RE: Letter of Intent
WWSD South Tank
JVA Job No. 240504.ENV

Project No. PPR 2431

Woodmoor Water & Sanitation District No. 1 (WWSD, District) proposes to build a 0.65-million-gallon (MG) finished water storage tank at their South Booster Pump Station (SBPS) site. The site is south of Colorado Highway 105 and east of Fairplay Drive, spanning between the cul-de-sacs of Jack Boot Way and Caribou Way off Caribou Drive East. The new tank will provide redundancy to the existing 1-MG potable water storage tank, allowing for critical repairs to the existing tank located on the same site. The goal of the project is to construct the new tank so repairs to the existing tank can be completed by 2025 to comply with Colorado Department of Public Health and Environment (CDPHE) requirements.

SITE DEVELOPMENT PLAN

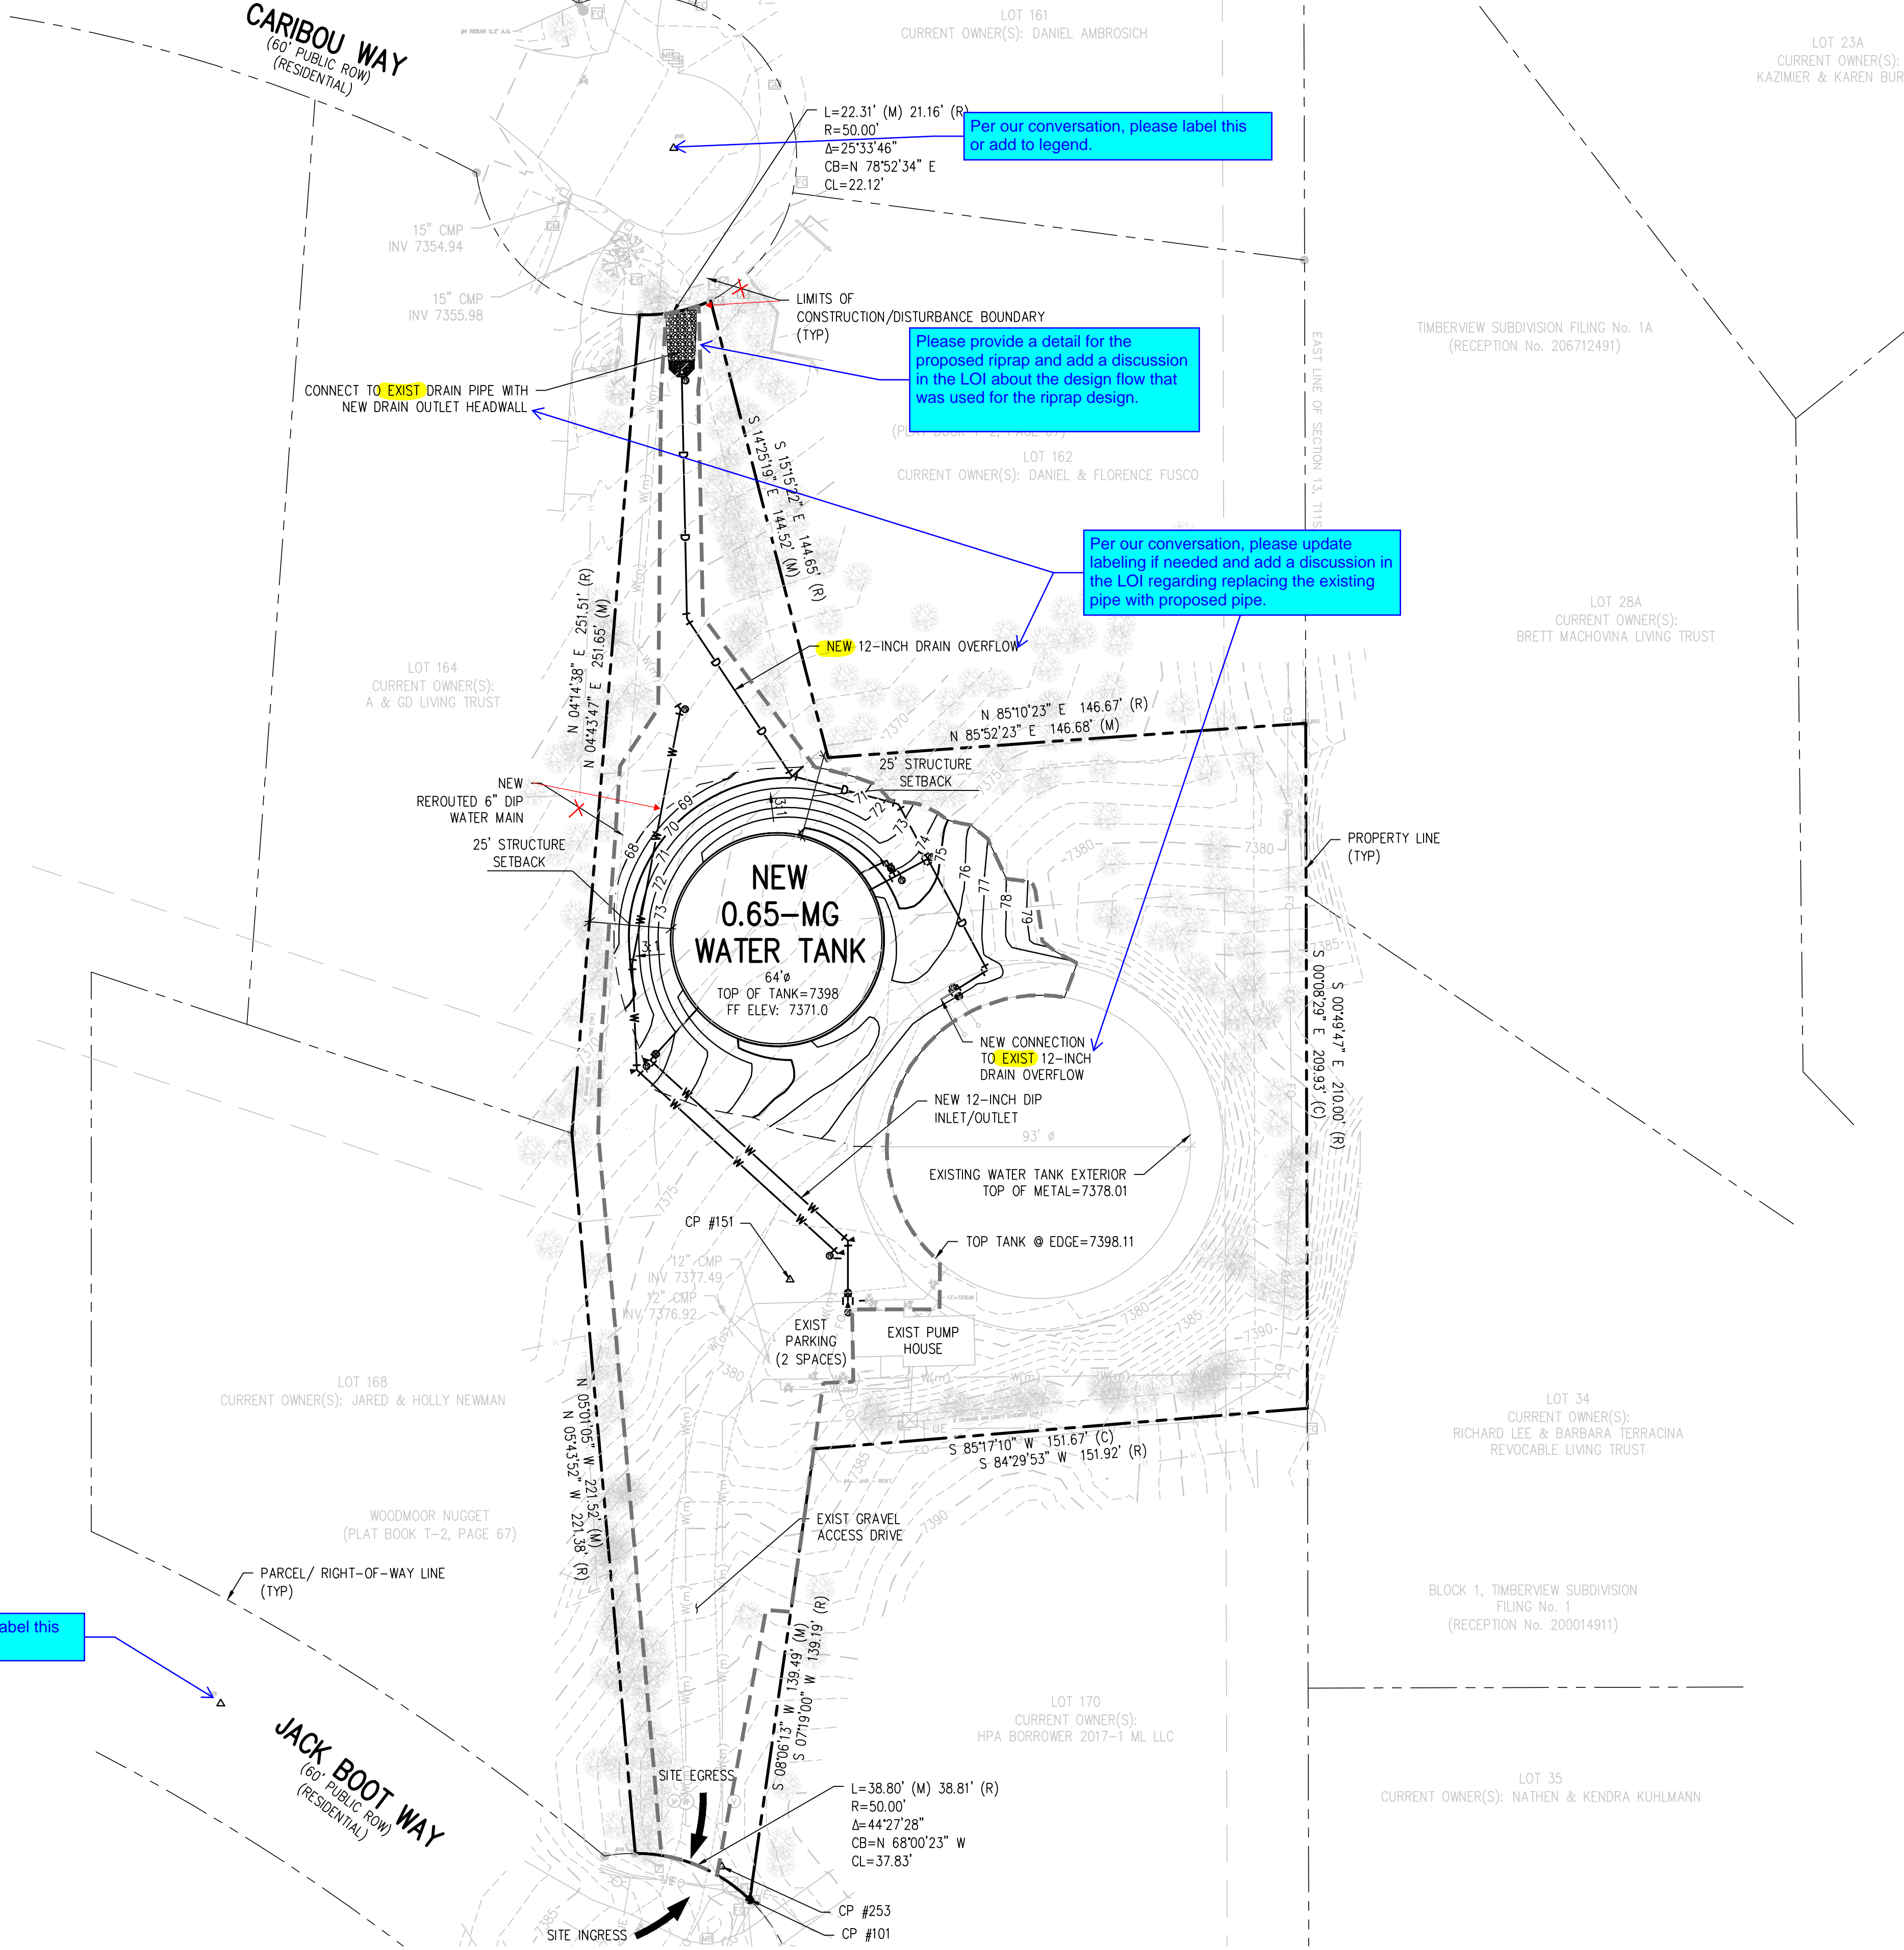
Please discuss the drain pipe and if there will be any change or increase in the anticipated pipe flow rate?

ALTERNATE LANDSCAPE PLAN

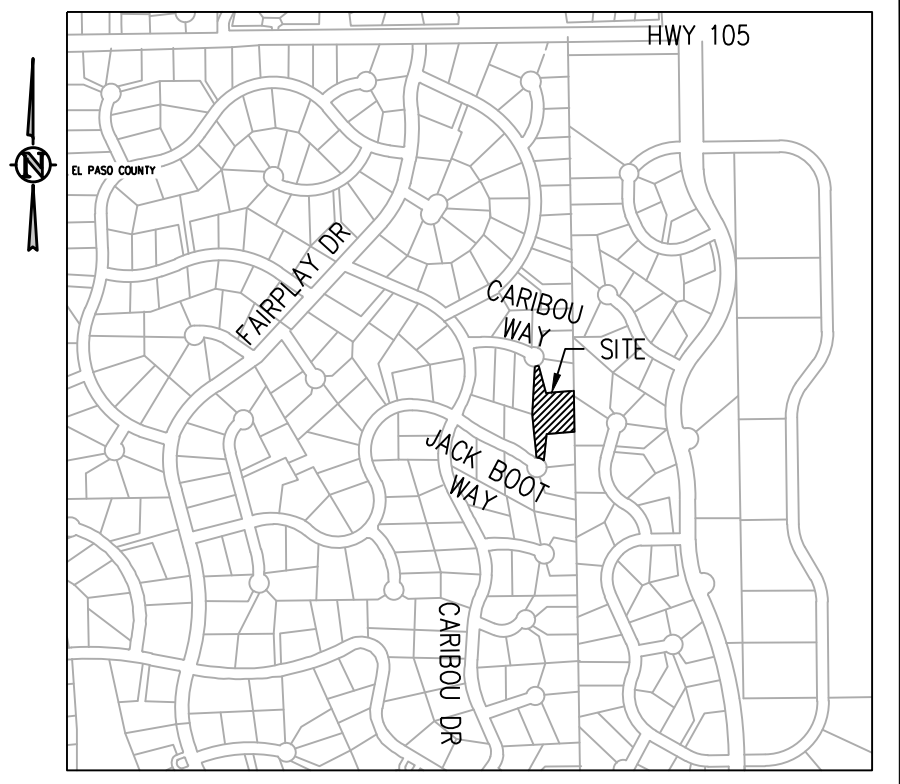
Note: staff requires additional landscaping between tank and residential area for more buffer and screening.
